From: Laura Gibbons
Sent: 19 April 2018 08:41
To: Planning.Responses
Subject: RE: Planning Consultation on: AL/40/18/PL

APPLICATION NO: **AL/40/18/PL**

Site Address: Land Adjacent to 14 St Johns Close Westergate PO20 3TH

Description of Works: 2 No. semi detached bungalows with associated parking & landscape

location plan &
proposed site plan

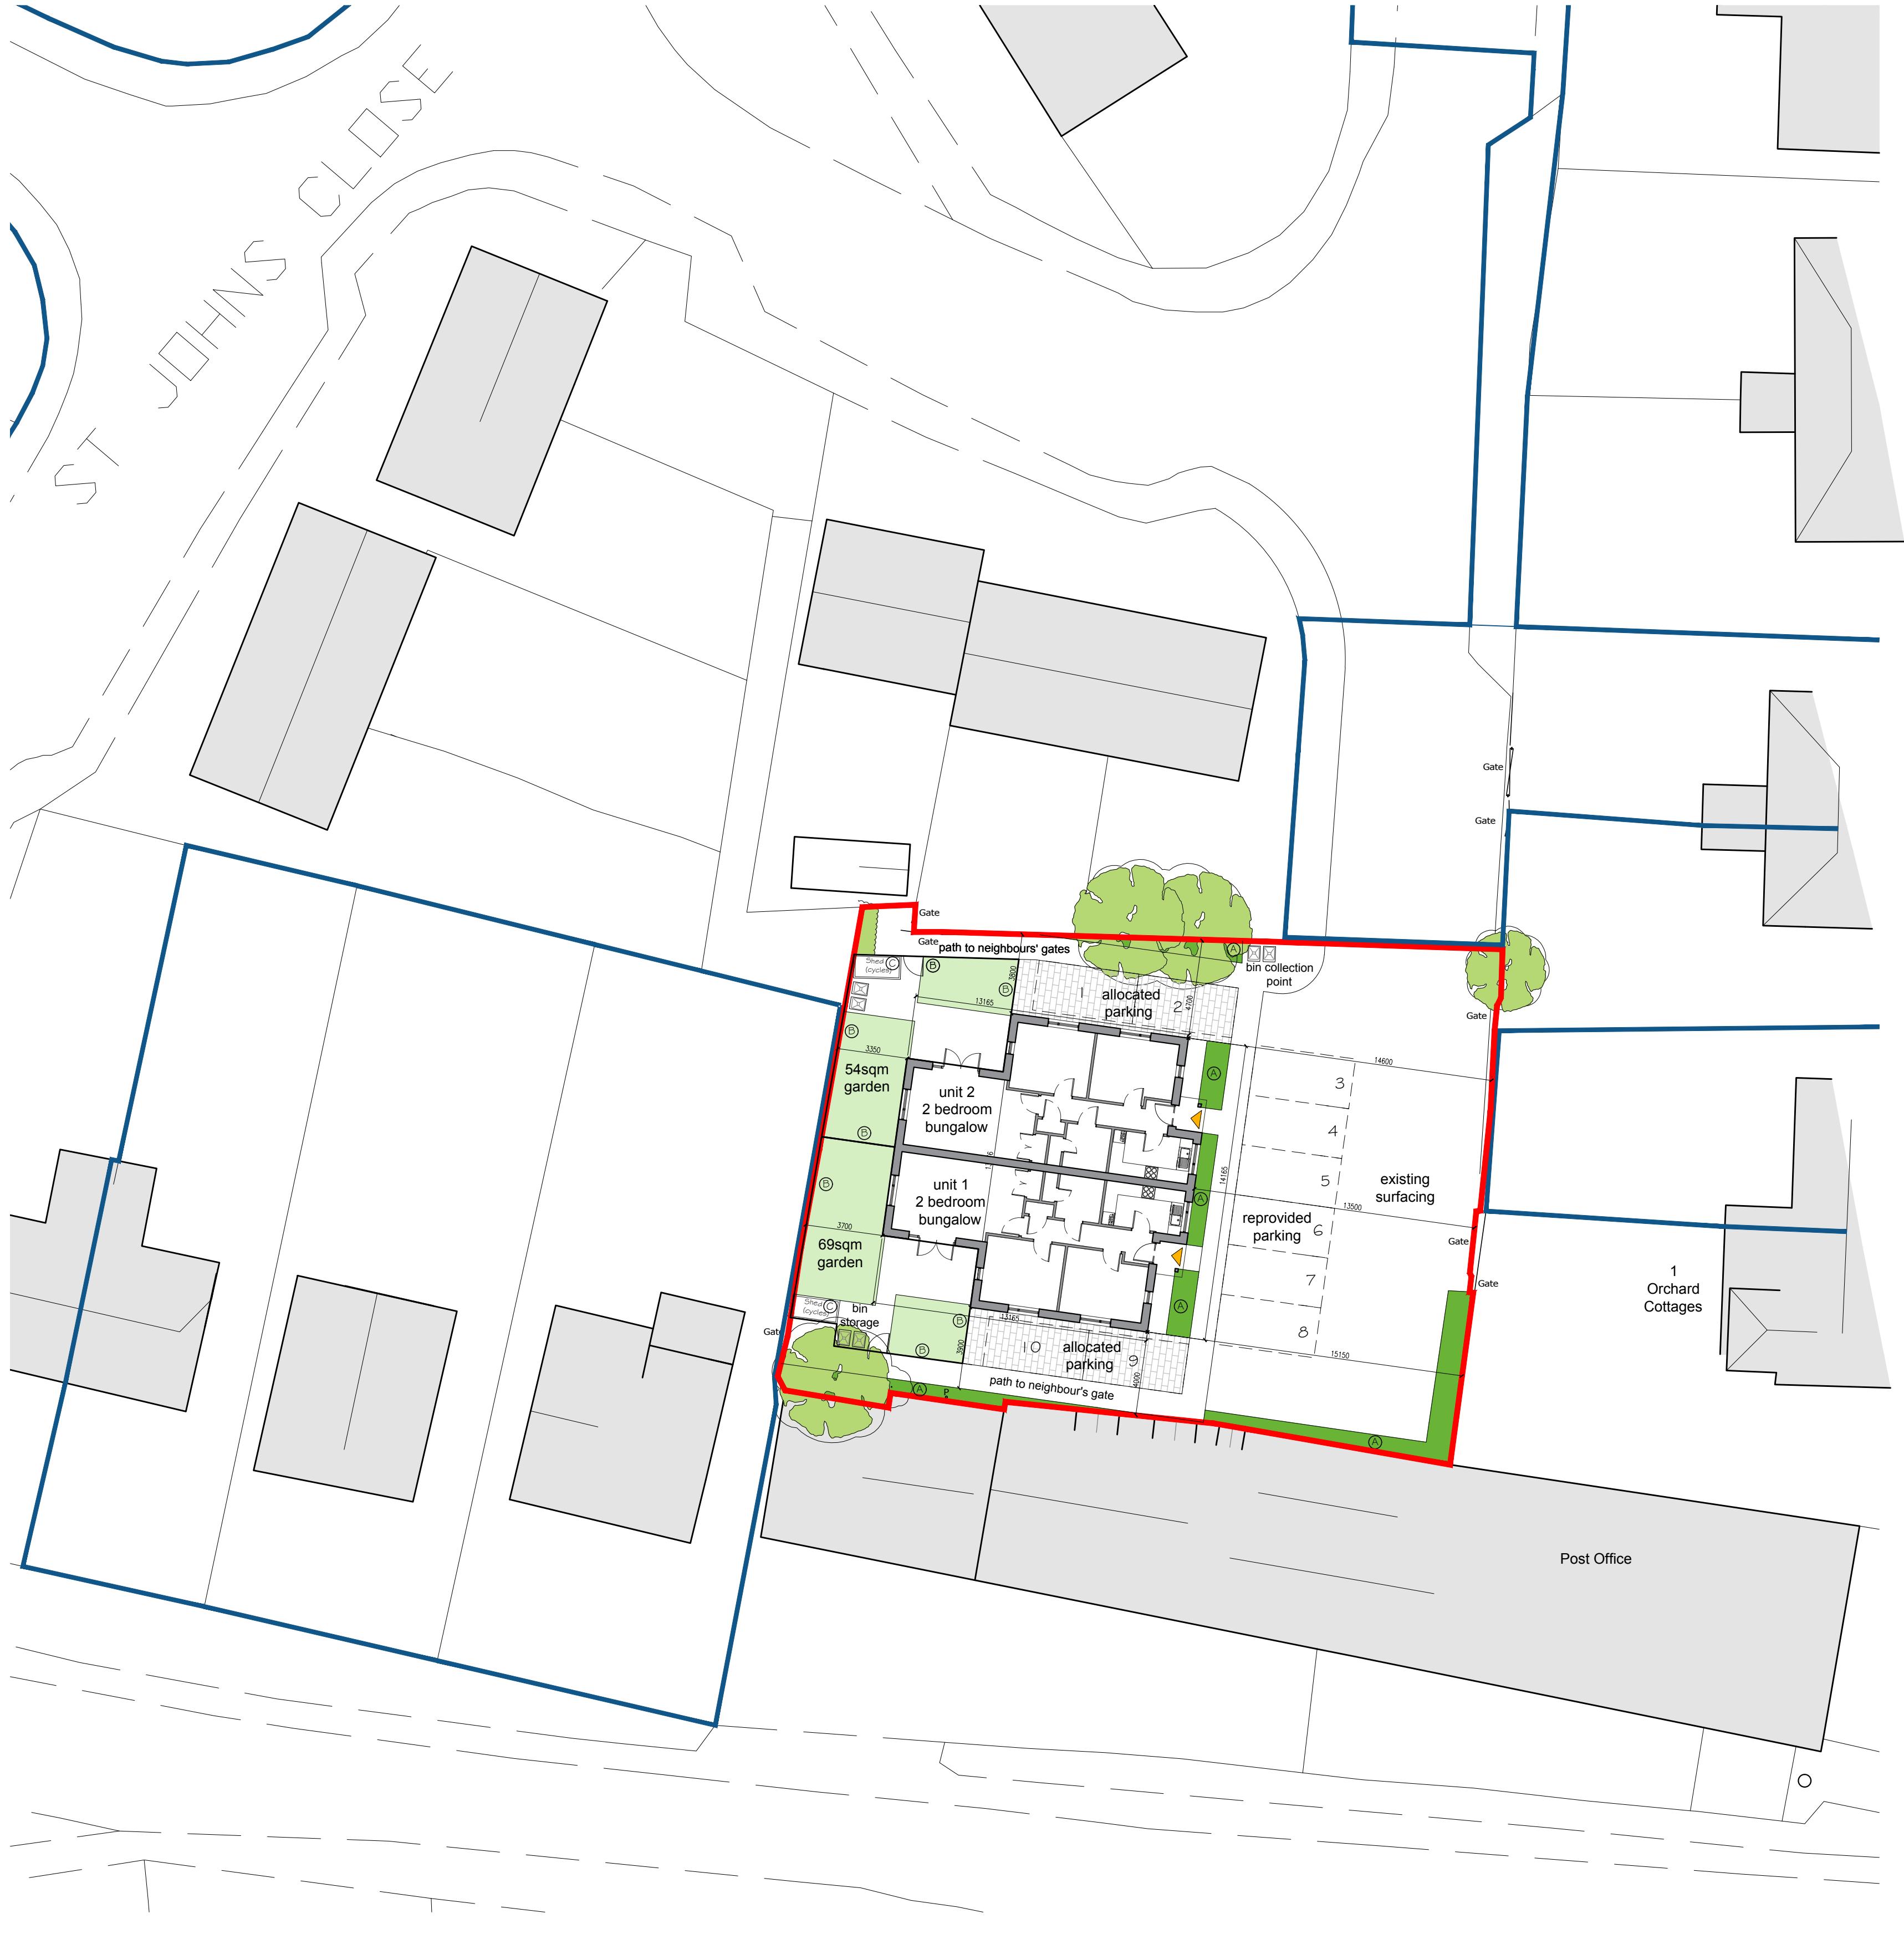
There is a surface water and foul water sewer running through the proposed development. Early consultation with Southern Water is advised.
